Tulip Design

Our ref: TD/AP/02

23rd June 2009

Re: Proposed Dwelling at R/O 29 High Street, Moulton. H13/0390/09

Block Plan
1:500 approx

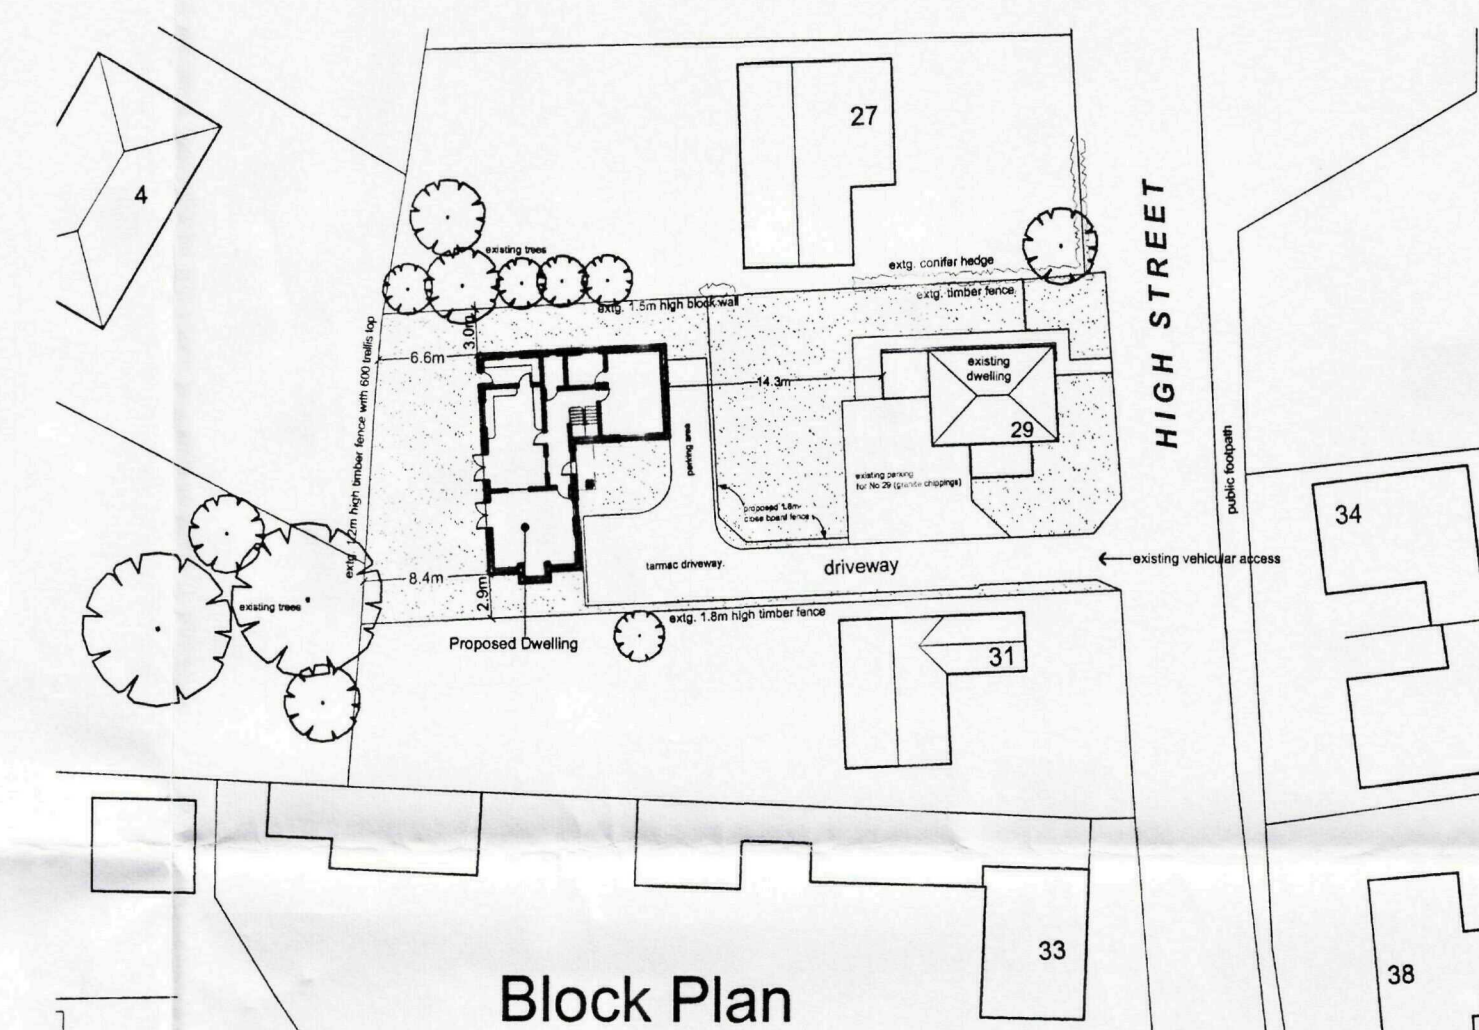
The amended plans now incorporate alterations to the existing parking arrangements for No 29. These were shown incorrectly on the original plans and have now been amended and incorporated on the attached plans (09/008/001 A).
